Cherokee Metropolitan District, Additional Office Space (Swan Road),
PPR-17-061

Please accept the following comments from El Paso County Public Health regarding the project referenced above:

PROJECT TITLE:	11'-9" X 60' OFFICE - ACTON MOBILE	
DRAWING TITLE:	PROJECT NO:	SHEET NO:
COVER PAGE	15280-01	A00

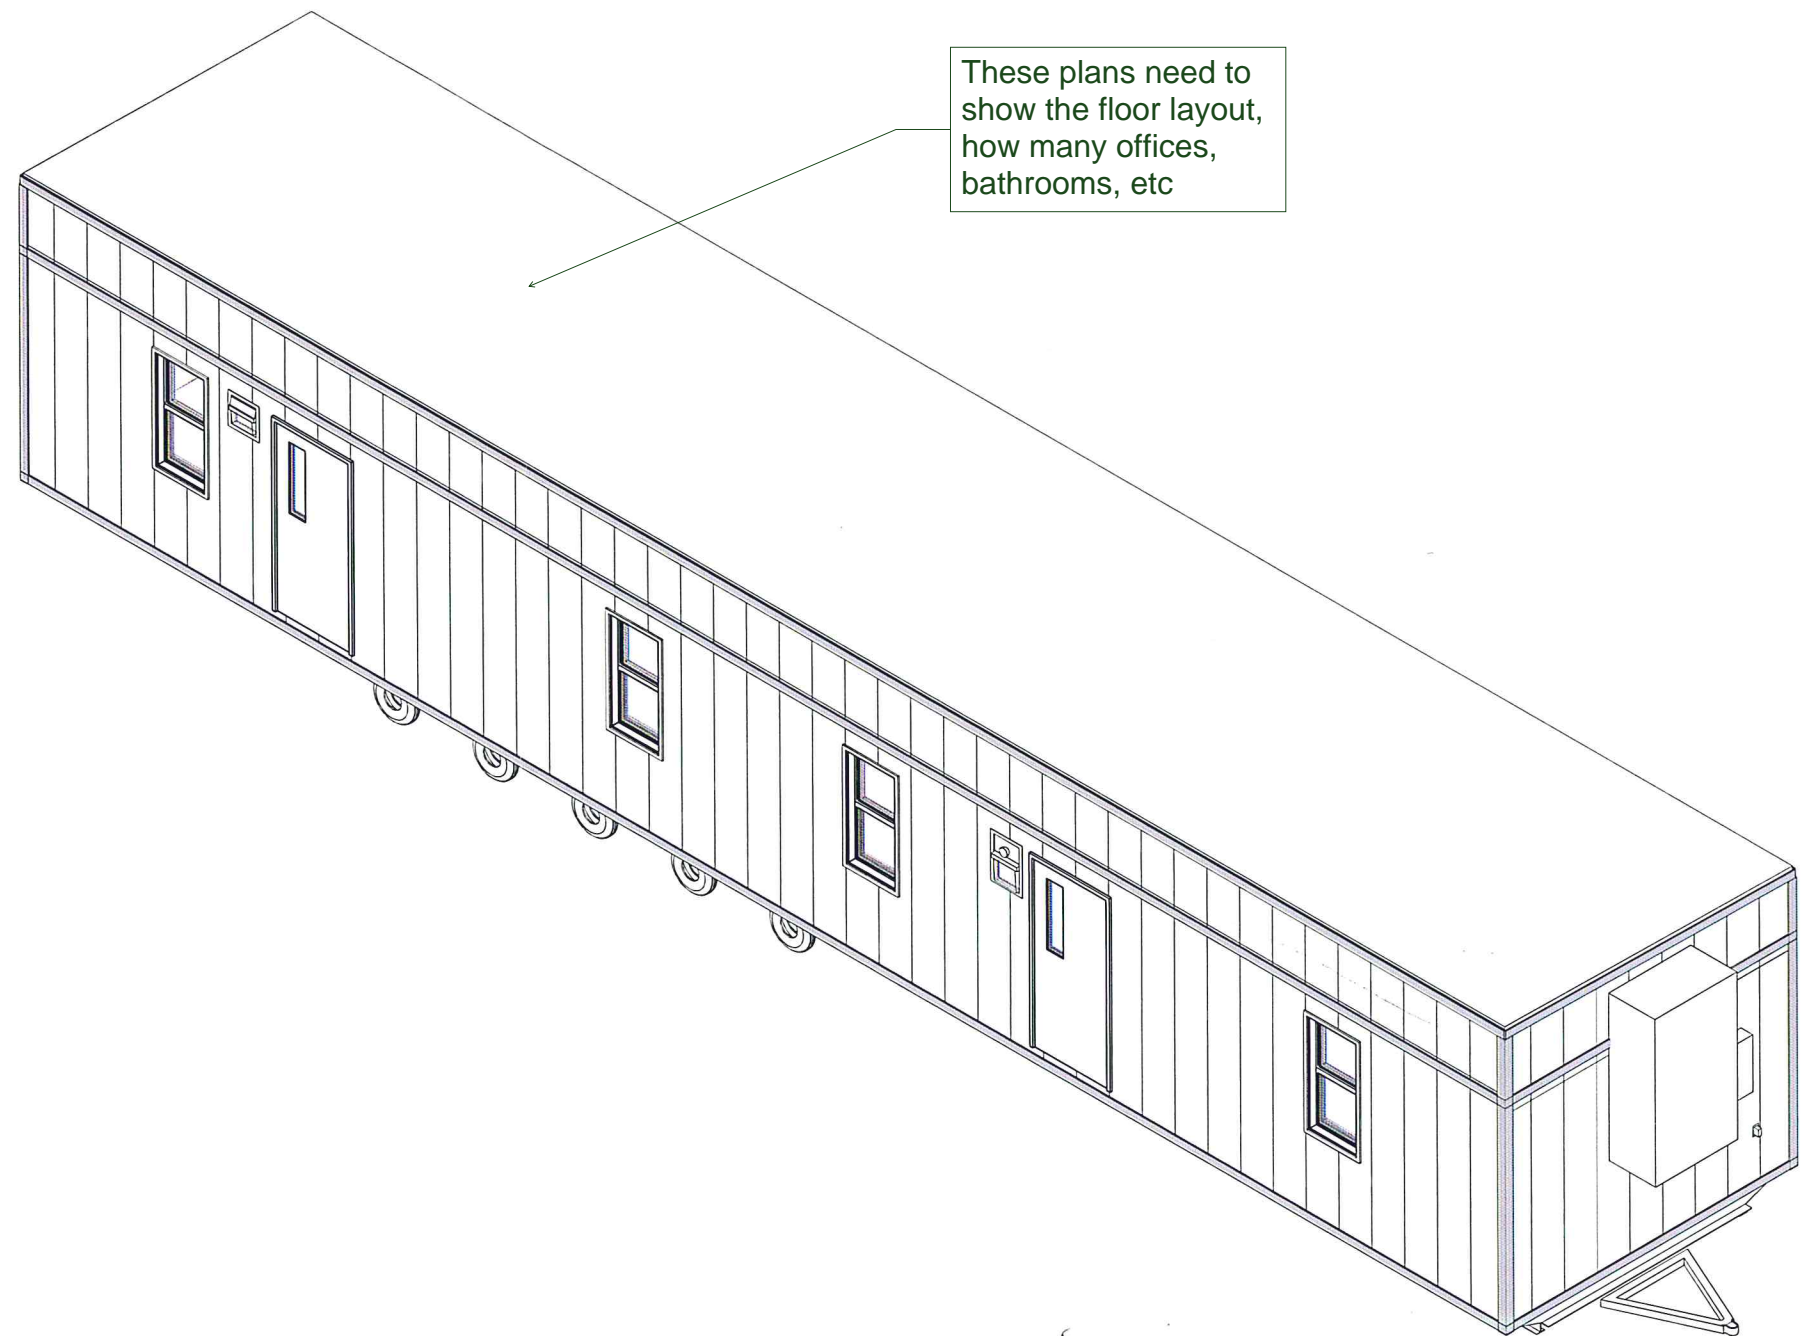
- The proposed additional office space does not include a restroom; therefore, access to the restroom at the existing 1-story house on the lot is required whenever the new office space is available to employees. If the office hours were to be different between the new office space and the existing house, then access to a restroom via other means (lock/key, cipher lock, etc...) is acceptable.
- The existing house has an approved onsite wastewater treatment system (OWTS) approved in 1987 for a 2 bedroom house. A review of the capacity of the existing OWTS by a Colorado Registered Professional Engineer for the increased wastewater flow associated with the office space/employees is required to be submitted to EPCPH for review.
- No other El Paso County Public Health issues noted with the approval of this request.
